Consultation Response from KC, Highways Development Management
2025/91579 The Homestead, Hurst Knowle, Almondbury, Huddersfield, HD5 8SG
Demolition of the former Homestead care home and erection of 28 dwellings, comprising 20 apartments and 8 bungalows, with access from Hurt Knowle and associated external works including landscaping
Date Responded: 25-11-2025. Responding Officer: Mark Berry. Responding Ref: 11-6NW-13.

Appendix 4:
Tree Protection Plan
The Homestead, Hurst Knowle, Almondbury
Ref: AWA6641AMS
BRITISH STANDARD 5837:2012
SCALE: 1:500 PAPER: A2

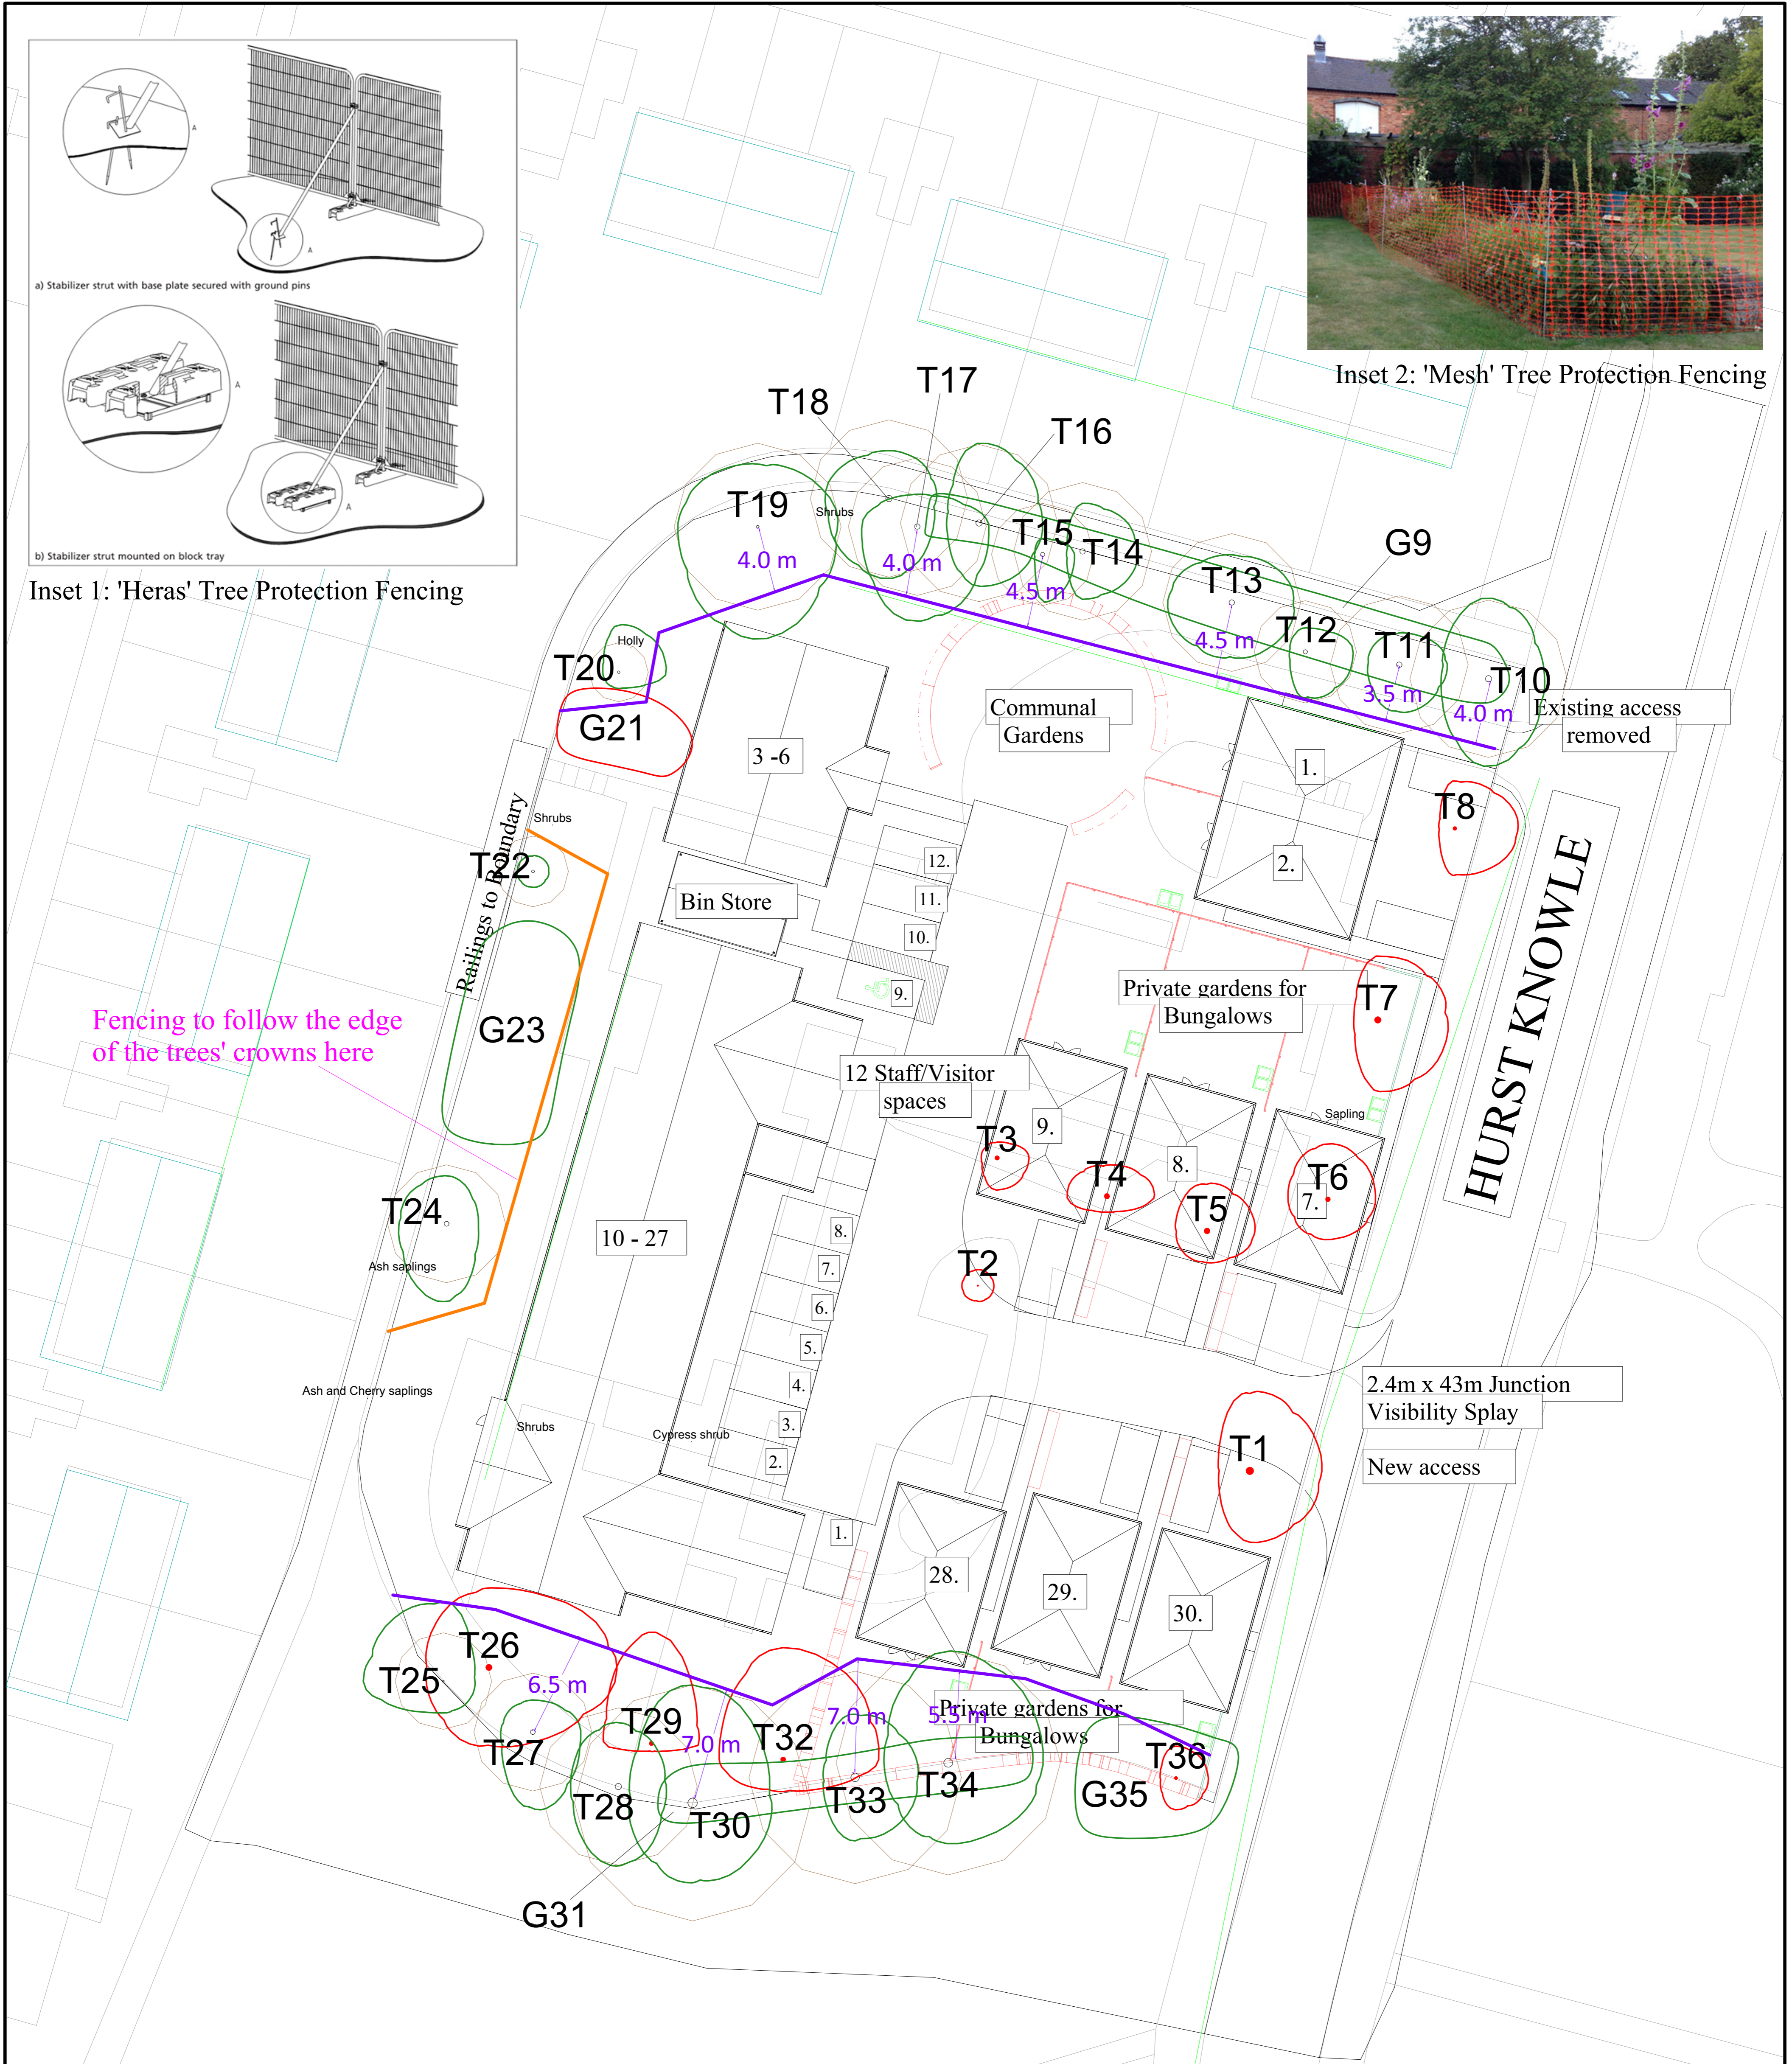
2, No pedestrian access is shown to be provided into the site. H D M would therefore recommend that pedestrian access is provided by returning the footways around the radii into the site and providing a traffic calming ramp at the access similar to the attached standard detail.
